HAYES STRUCTURAL
Consulting & Design, PLLC

Re: 24-FRM-019
Framing Inspection
50 Alban Row
Fuquay-Varina, NC 27526

At your request, a site visit was made to the above referenced single family residence to inspect the fire-damaged roof framing members within the walk-up attic. Additionally, the permitted plan set for the attic conversion was reviewed.

CONVERTED ATTIC CEILING FRAMING PLAN

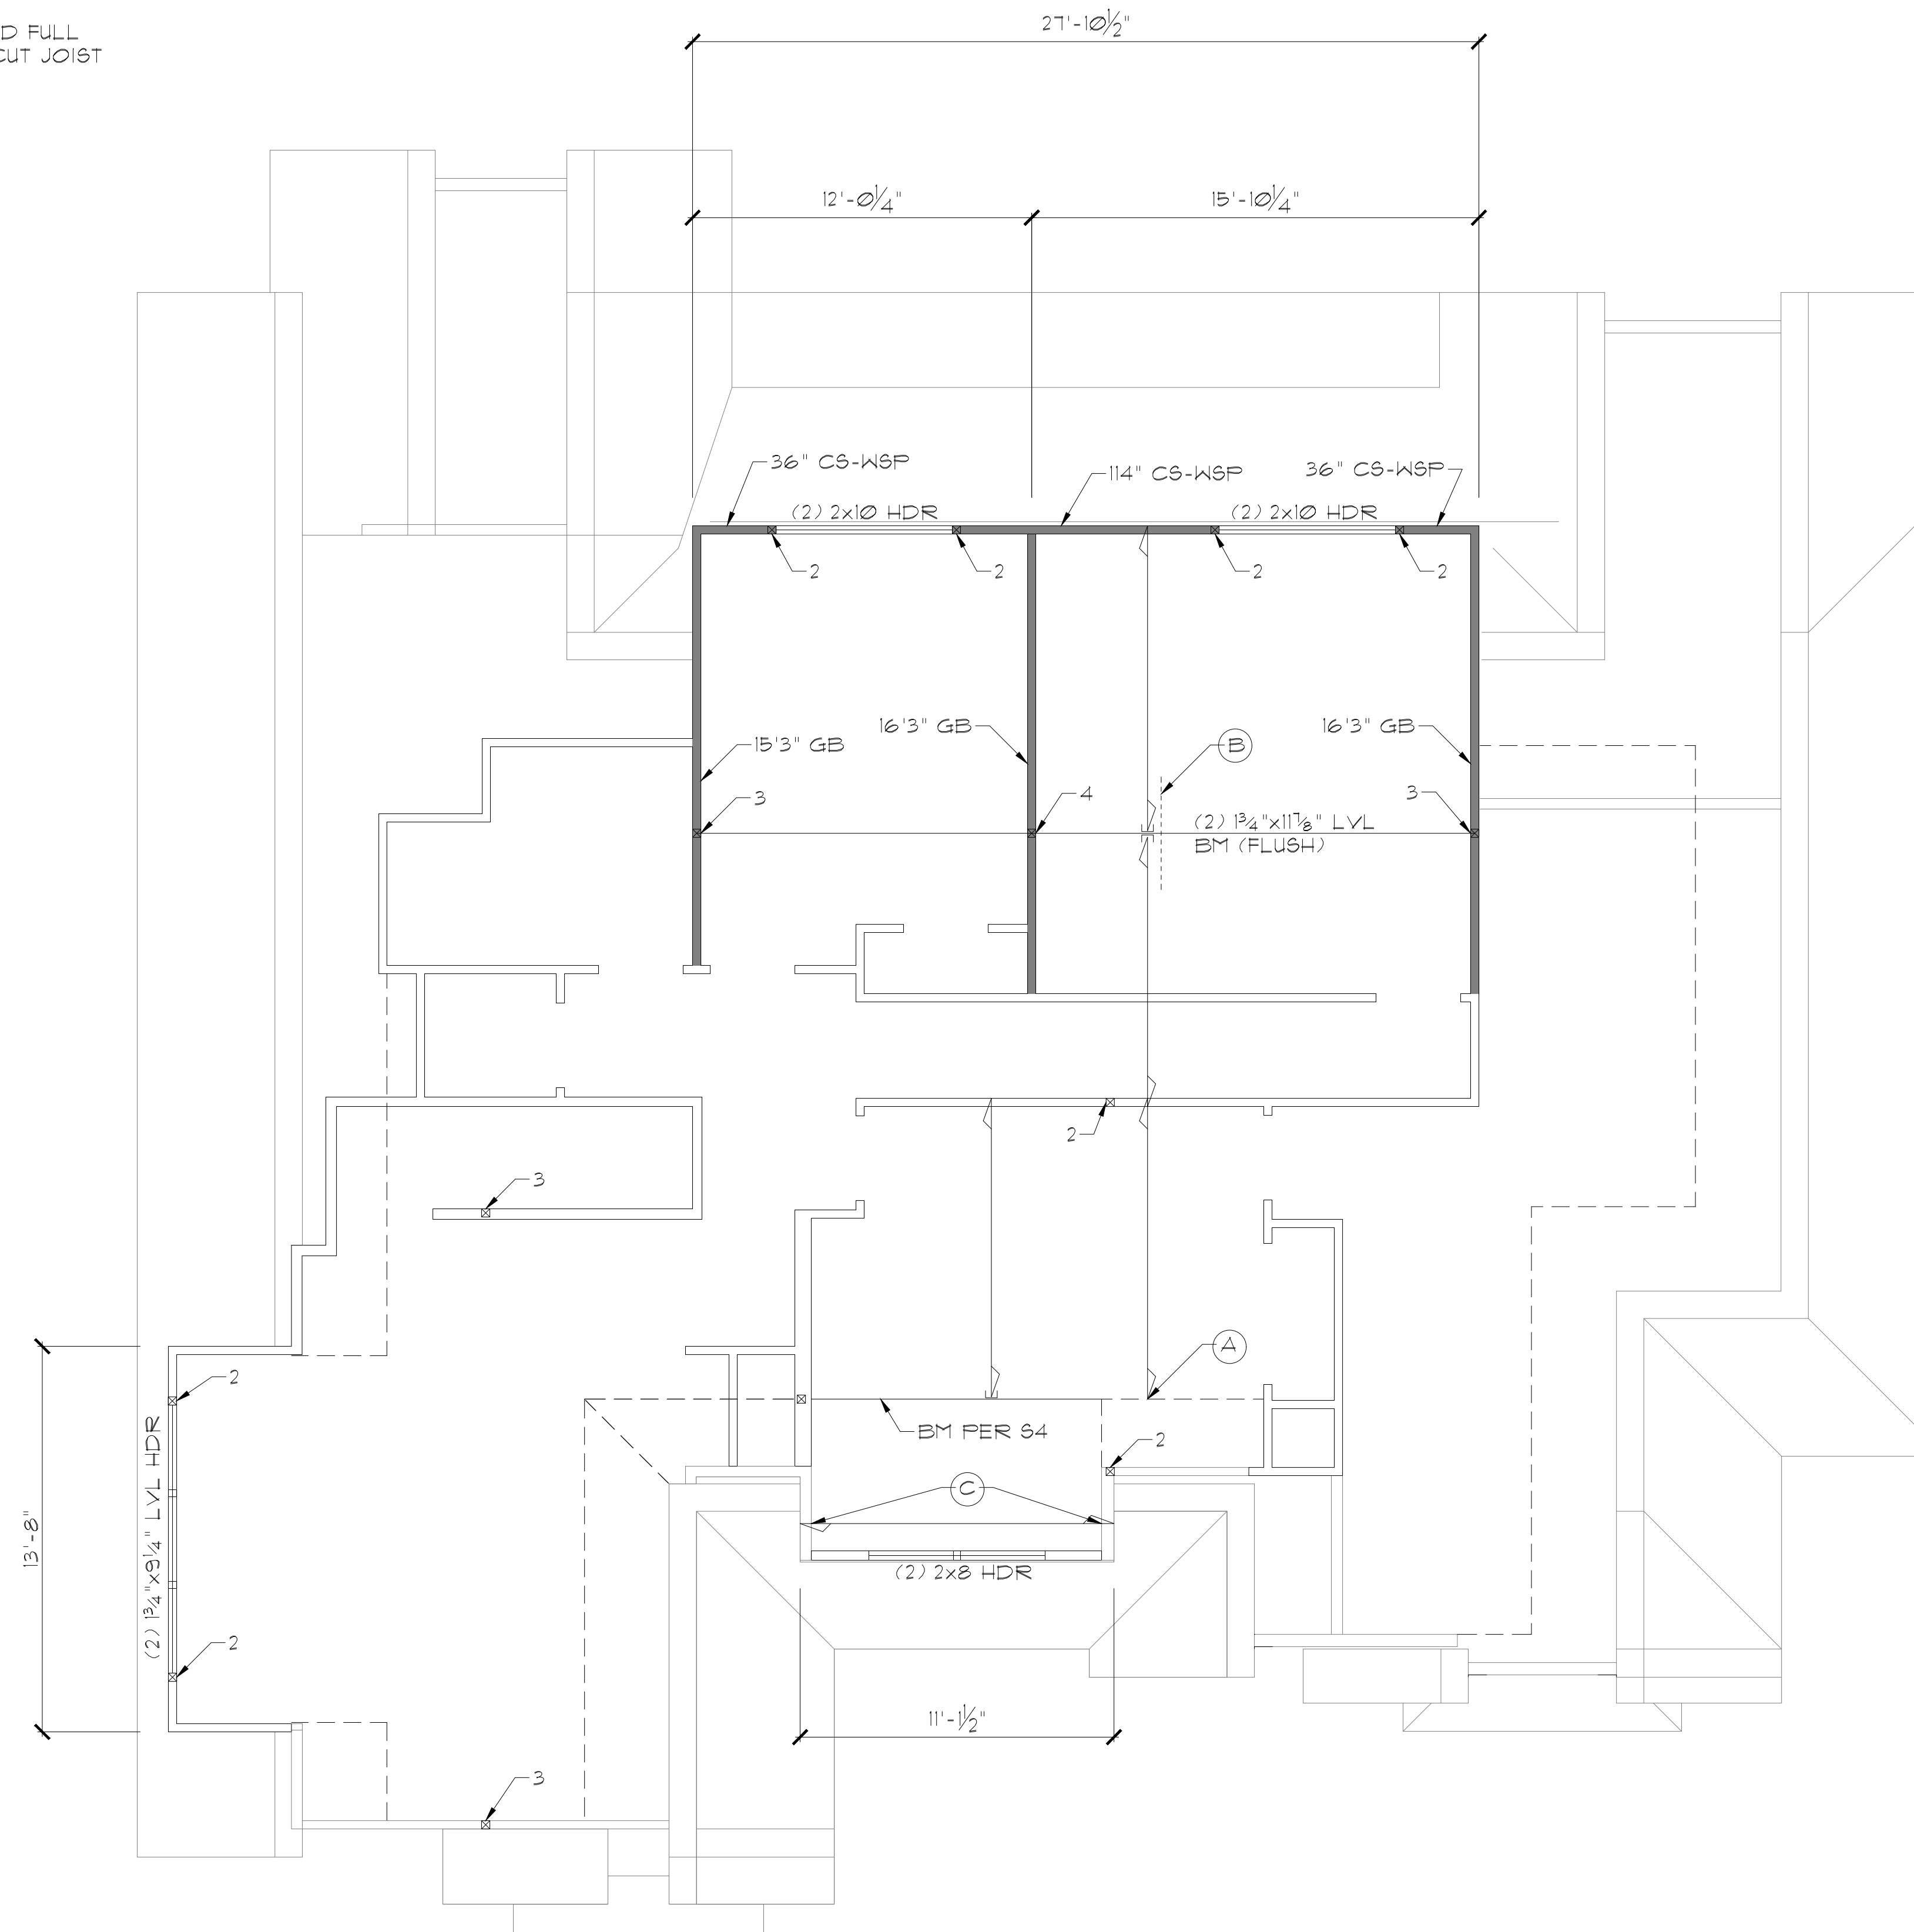
1. The rafters at the rear side of the attic above the kitchen and living room were observed to have minor to moderate charring, with the worst charring at the top of the rafters. The rafter ties and collar were observed to have moderate to severe charring. The rafters above the front side of the attic above the dining room and foyer were observed to have minor charring. Review of the permitted plan set revealed a large shed dormer to be constructed at the rear side of the attic and a gable dormer to be constructed at the front side of the attic.
2. The 2x10 ridge and furring strip spanning left to right above the center of the attic were observed to have minor to moderate charring. The worst charring was observed along the underside of the furring strip.
3. The (2) 2x10 hip at the left rear side of the attic above the secondary bedrooms was observed to have moderate to severe charring.

1. The noted rafters at the rear side of the attic may remain in place, however, each rafter is to be reinforced with an additional 2x8 rafter sistered with (3) staggered rows of 10d nails spaced 16" o.c. Added rafters are to be fastened to the ridge with (3) 10d toe nails. Reinforced rafters at the new rear dormer are to be cut back to bear on the new LVL flush beam as specified on the permitted structural plans. The charred rafter ties are to be removed and replaced with new ceiling joists per the permitted structural plans. The charred collar ties are to be removed and new 2x4 collar ties are to be installed at a maximum spacing of 48" o.c. per code. The noted rafters at the front side of the attic do not require reinforcement.

2. The noted 2x10 ridge may remain in place. The noted charred furring strip is to be removed and replaced with a new 2x furring strip to allow the rafters to have full bearing. The furring strip is to be fastened to the ridge with (1) row of 10d nails spaced 8" o.c.
3. The noted (2) 2x10 hip is to be removed and replaced with a new (2) 2x10 hip. Plies of the hip are to be fastened with (3) staggered rows of 10d nails spaced 16" o.c. Rafters supported by the hip are to be fastened to the hip with (3) 10d toe nails.
